Railway Order – Dublin to Cork Railway Line (Eliminate and Upgrade of Level Crossings between Limerick Junction and Mallow) Order 2021

Case reference: NA04.310286

Following representations from numerous constituents, we, the above noted Councillors wish to make a submission to An Bord Pleanála in relation to the proposed upgrade and improvement works at Thomastown and Fantstown.

Figure 2.3: XC187 Fantstown Proposed Solution

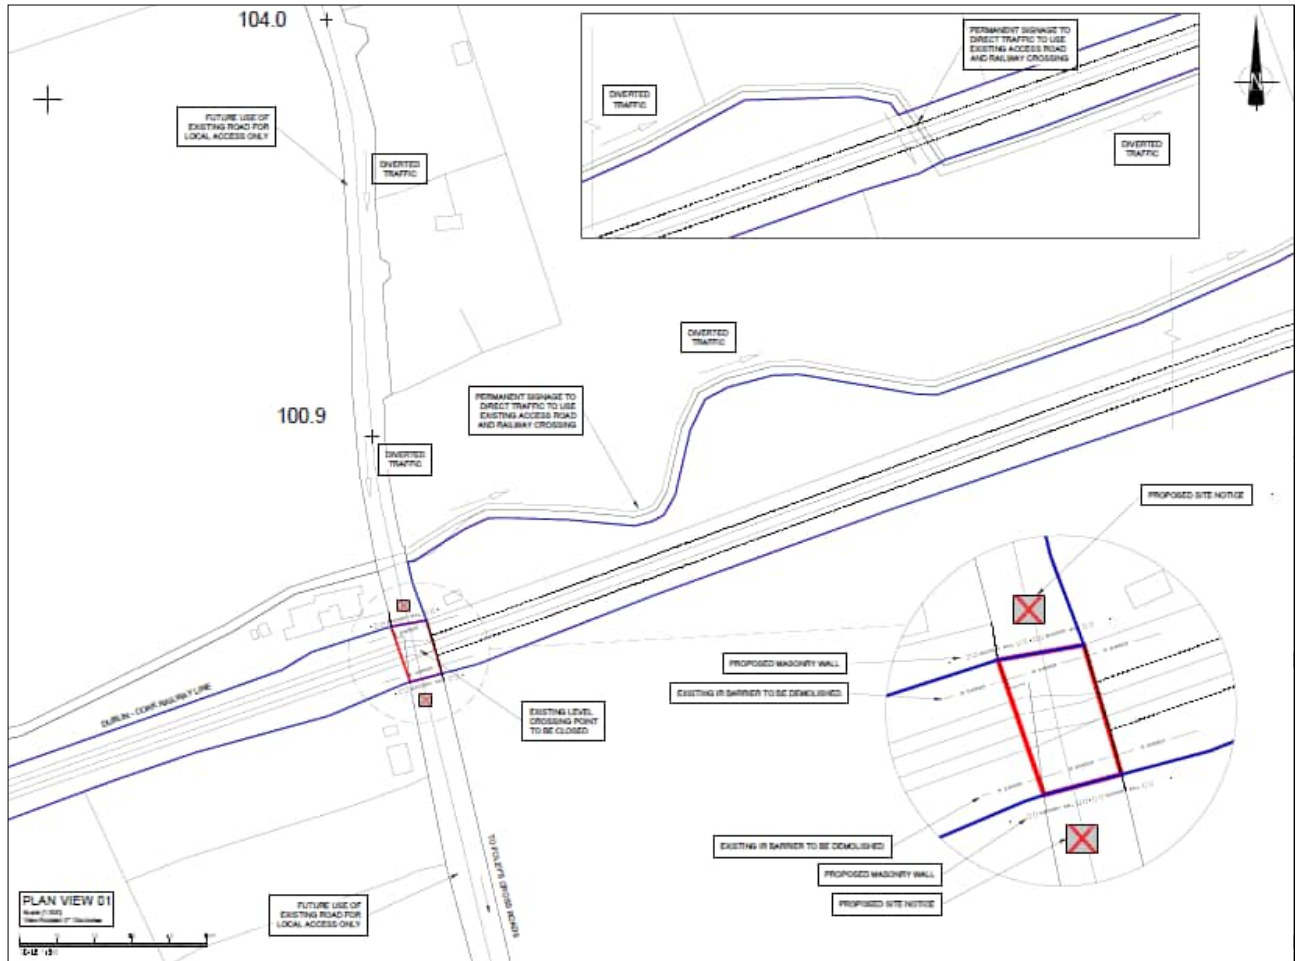
Our comments in relation to the Fantstown proposals are as follows:

The proposals as currently set out will split the parish of Bulgaden Martinstown and divide the community and access to Staker Wallace New GAA Grounds. It is a very popular loop walk and necessary for landowners on both sides and residents who have used this for generations. Lands need to be accessible for pedestrians and vehicles. We would be grateful if the new proposals as presented by Iarnród Éireann here can be reconsidered.

Figure 2.5: XC201 Thomastown Proposed Route Alignment

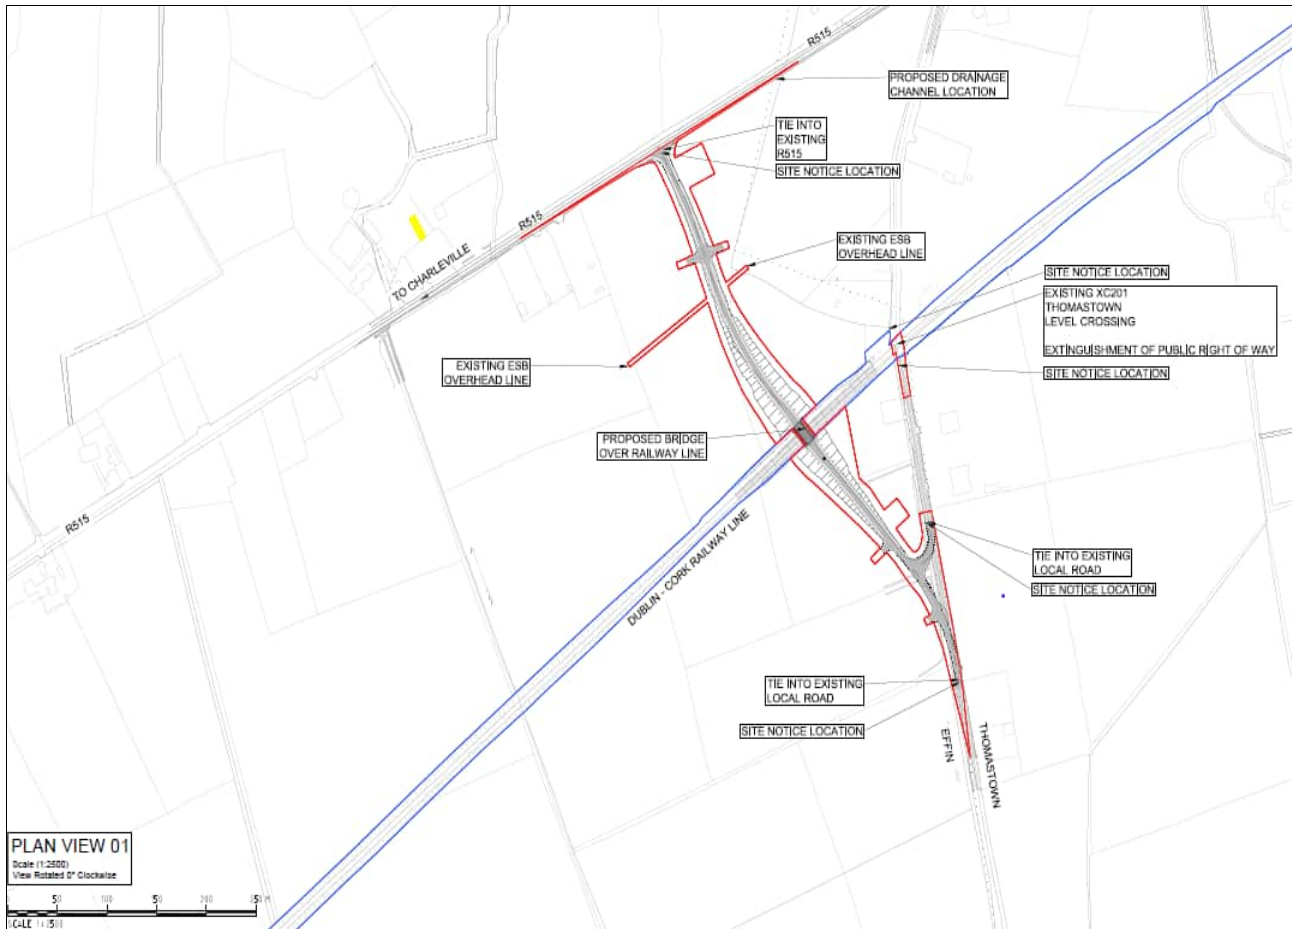
Our comments in relation to the proposals at Thomastown, Kilmallock Railway Crossing relate to the serious grounds of Health and Safety for all road users as follows:

We request that a double lane road over the railway be accommodated for all vehicular traffic and for accessing and exiting the junction in a safe manner. This should also incorporate 'stacking lanes' from both directions on the Main Charleville - Kilmallock road in the interests of further road safety as a result of the ongoing huge volume and consistent speed of traffic.
